## WEST SUSSEX COUNTY COUNCIL CONSULTATION

| <b>FROM:</b>                    | WSCC - Highways Authority                                                                                                                                                                                                                                                                                                                                                                                                       |
| <b>LOCATION:</b>                | Co-op Stores<br>2 Nyetimber Lane<br>Bognor Regis<br>PO21 3HG                                                                                                                                                                                                                                                                                                                                                                    |
| <b>SUBJECT:</b>                 | AW/359/20/PL<br><br>Introduction of one way system & marked <u>parking</u> bays to the existing parking area, new armco barrier to protect shopfront, new mechanical plant at rear of store with key-klamp protectio

project			
CO-OP SUPERMARKET			
2 NYETIMBER LANE,			
ALDWICK			
BOGNOR REGIS			
PO21 3HG			
SITE PLAN			
date		drawn	C.J.J.
DEC 20			
scale	1:200,500,1250 @A1	drg no.	3582.12

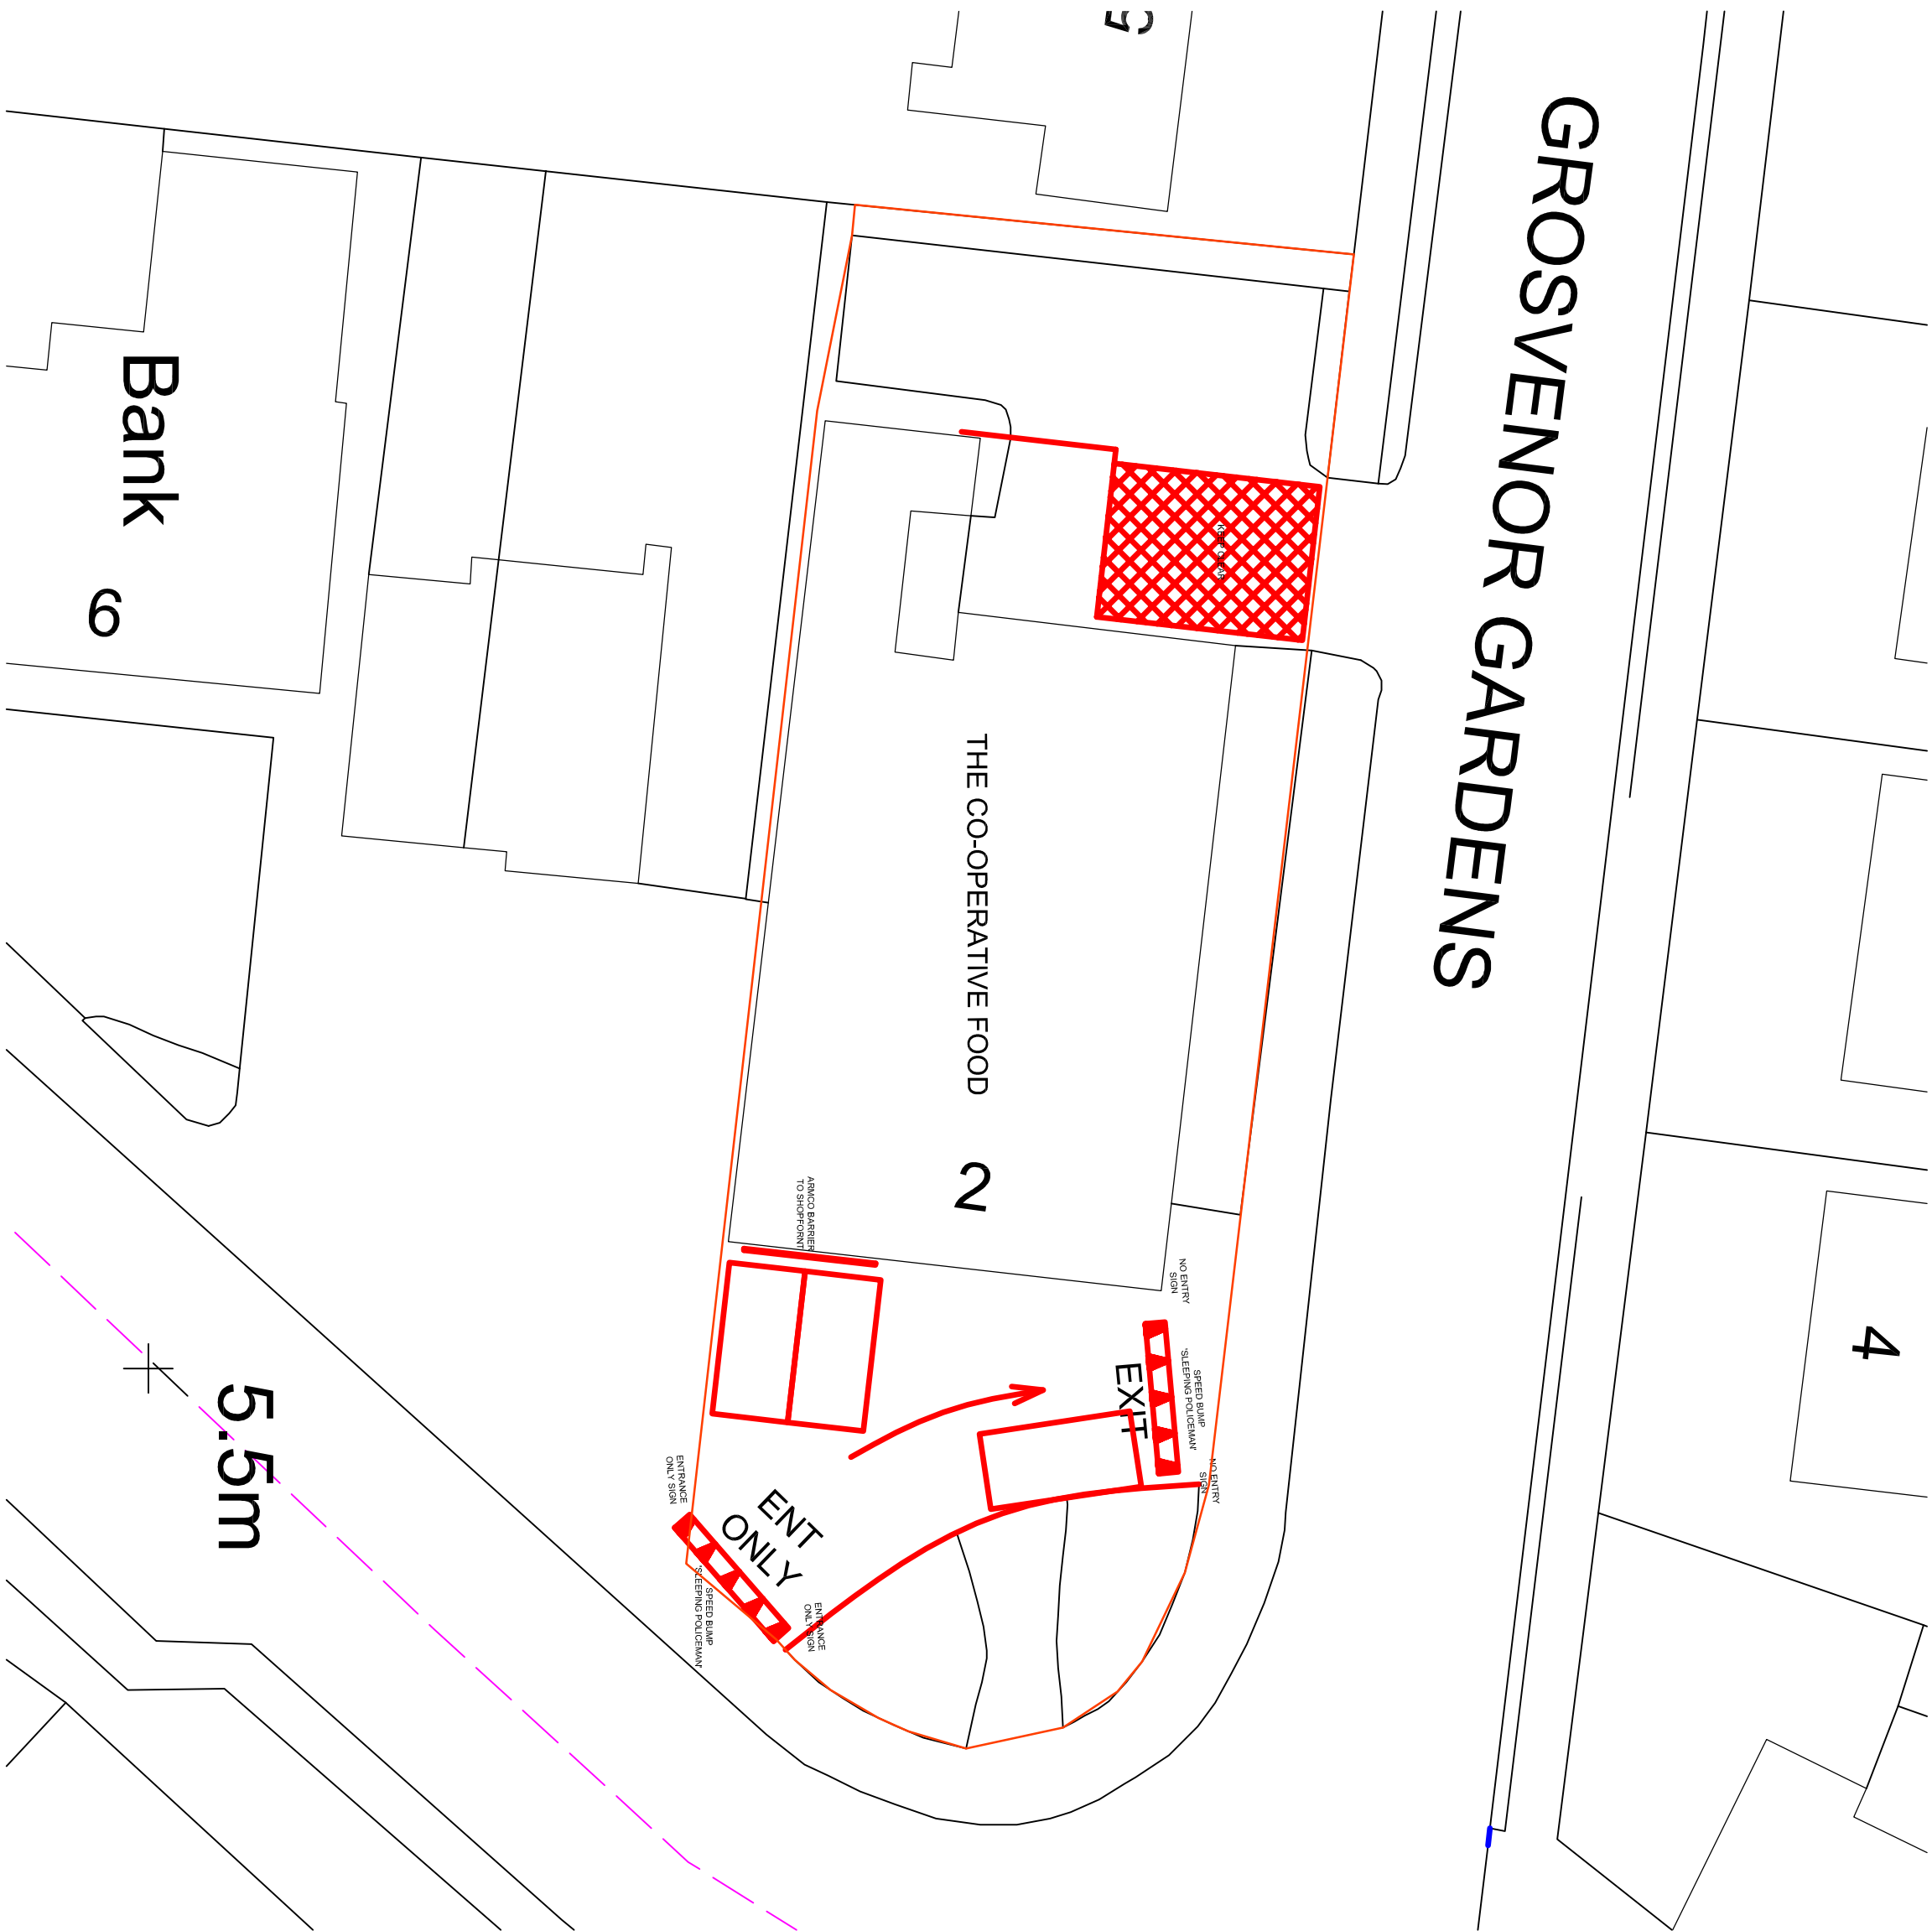
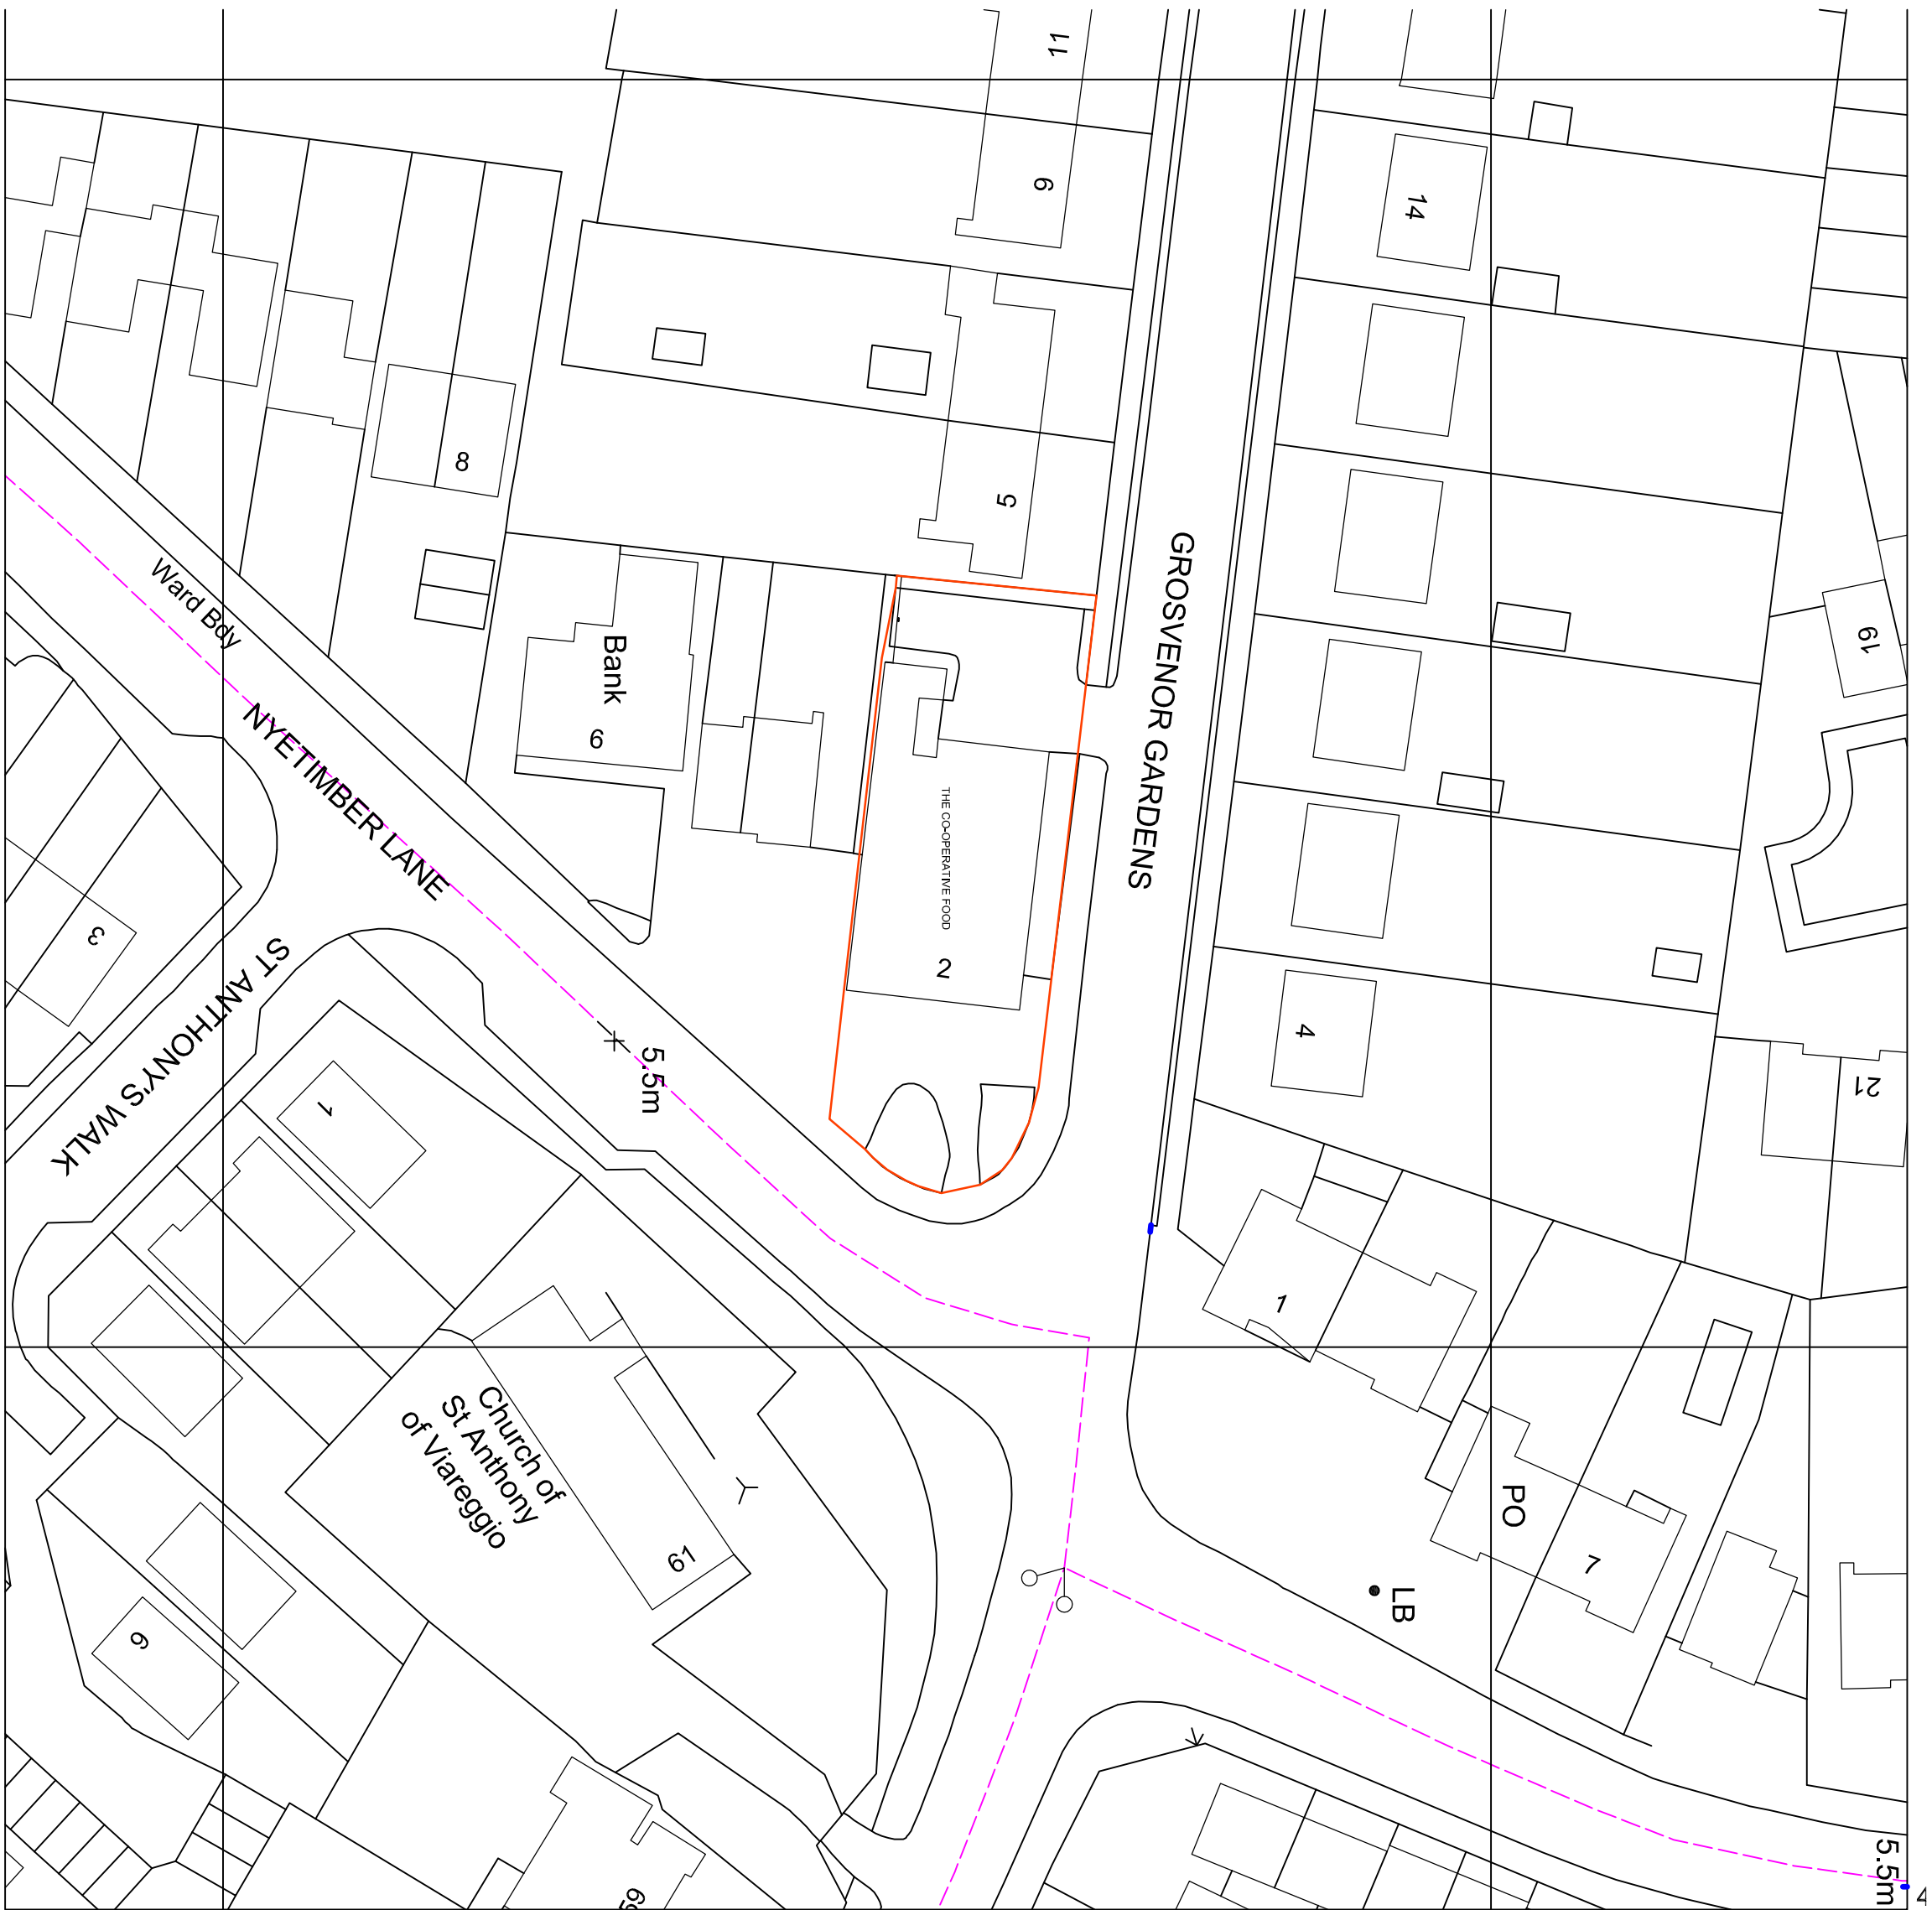
The proposal is to make the access from Nyetimber Lane the entrance, with a raised speed reducing ramp and signage. Then to make the Grosvenor Gardens access into the exit only route, again with a raised speed reducing ramp and signage as detailed in the site plan (drawing no:3582.12). 3 parking bays are proposed to be formally marked out. The bay located towards the exit covers the pedestrian access route to the store. It appears this is how the site operates historically. The two other bays would operate as drive in reverse out bays, this is not expected to cause a safety issue and appears to have already been occurring historically. Although the proposed ramp may hinder this reversing manoeuvre.

and east without over running of the kerb edges. This needs to be improved/ widened to the east towards the traffic lights, approximately in line with the black metal post.

All proposed works appear to be within the sites red line boundary so will take place on private land. Except for the speed bump at the entrance which appears to be slightly on highway land (footway). This will need to be moved in so it's not on highway land.

With regards to traffic distribution if the proposals were approved there is no information currently submitted detailing current turning movements from the access/exit points, or a comparison if the one-way system is put in place. All vehicles exiting to the right (east) would have to wait to do so on a green light, which may hinder site movements during busy periods as the exit would be blocked whilst right turning vehicles wait.

Consideration needs to be given to the store's delivery vehicles, and where these park to service the store. The LHA are assuming near the rear store area, which has double yellow lines. There don't appear to be any loading/unloading markings/bays, it appears the lorry mounts the kerb whilst deliveries take place. Confirmation of store servicing should be clarified. With the exit being proposed onto Grosvenor Gardens only a delivery lorry would be blocking the visibility for any emerging vehicle turning out in either direction. Whereas now vehicles could exit using either access point.
